COMMUNITY SERVICES DEPARTMENT

Subject: Forest Lakes Filing No. 6 Final Plat, Review #2 (SF-20-027)

Forest Lakes Filing No. 6 Final Plat Development Application Review

14770

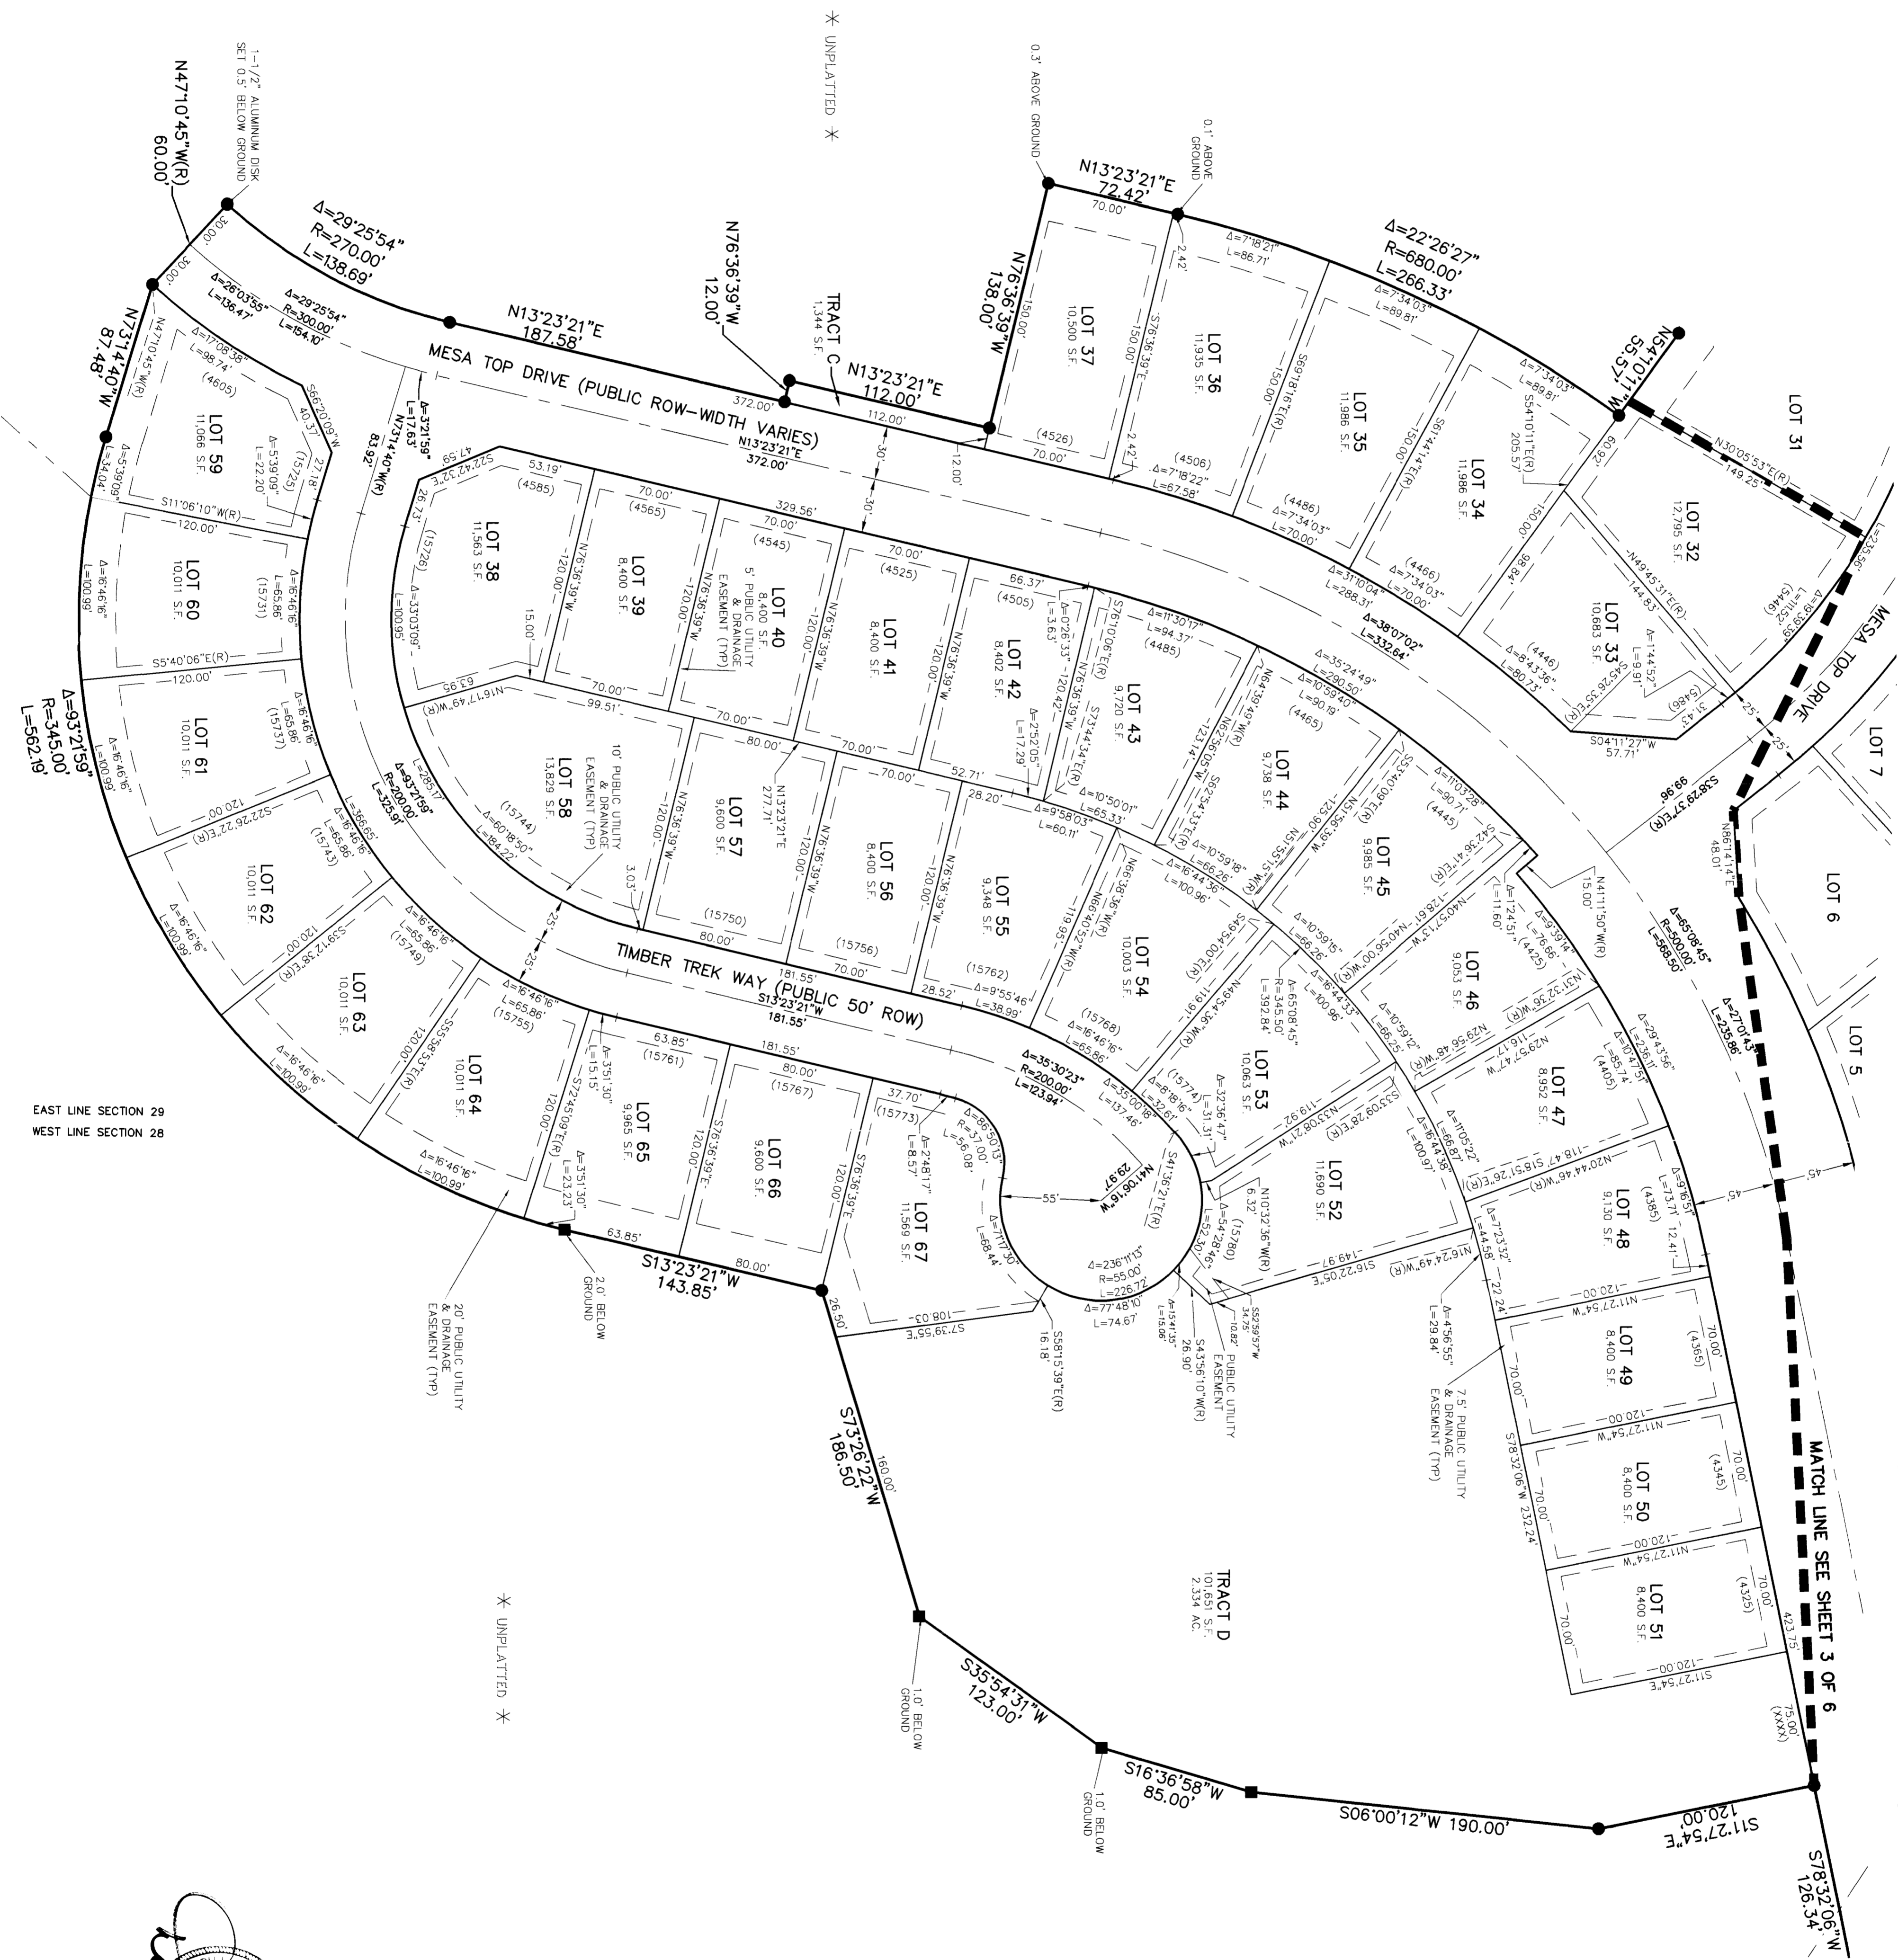
The BoCC-approved Forest Lakes Phase II PUD Preliminary Plan shows in detail the Forest Lakes Secondary Regional Trail, as well as the internal trail network and emergency access road. However, the Forest Lakes Filing No. 6 Final Plat does not show the 25-foot trail easement through the project site, and

the Final Plat notes do not reference the dedication of the trail easement to El Paso County. As such, staff recommends that the applicant include the easement alignment in the Final Plat drawings and include language in the Final Plat General Notes that designates and provides to El Paso County a 25-foot trail easement through Forest Lakes Filing No. 6, within Tracts A and B, that allows for public access of the Forest Lakes Secondary Regional Trail, and dedicate the aforementioned easement to El Paso County prior to the recording of the Final Plat.

The Park Advisory Board recommends that the Planning Commission and the Board of County Commissioners include the following conditions when considering and/or approving the Forest Lakes Filing No. 6 Final Plat: (1) designate and provide to El Paso County a 25-foot trail easement through Forest Lakes Filing No. 6 Final Plat, within Tracts A and B, that allows for public access of the Forest Lakes Secondary Regional Trail, and dedicate the easement to El Paso County within the Final Plat General Notes prior to the recording of the Final Plat; (2) regional park fees are not required pursuant to the existing Forest Lakes Phase I PUD Preliminary Plan and Filing No. 1 Final Plat recommended and endorsed motions; (3) the section of the Forest Lakes Secondary Regional Trail located within Filing No. 6 shall be constructed within two years of the recording of the Final Plat; (4) trail plans shall be submitted to and approved by County Parks prior to construction; (5) the trail shall be constructed to Tier 1 standards for a regional trail; (6) the trail shall be maintained by the Forest Lakes Metropolitan District when contained within developer-owned tracts, while El Paso County agrees to maintain the Regional Trail when contained within dedicated roadway rights-of-way; (7) require fees in lieu of land dedication for urban park purposes in the amount of \$20,060. A Park Lands Agreement may be an acceptable alternative to urban park fees, provided the agreement is approved by the County and executed prior to recording the Final Plat."
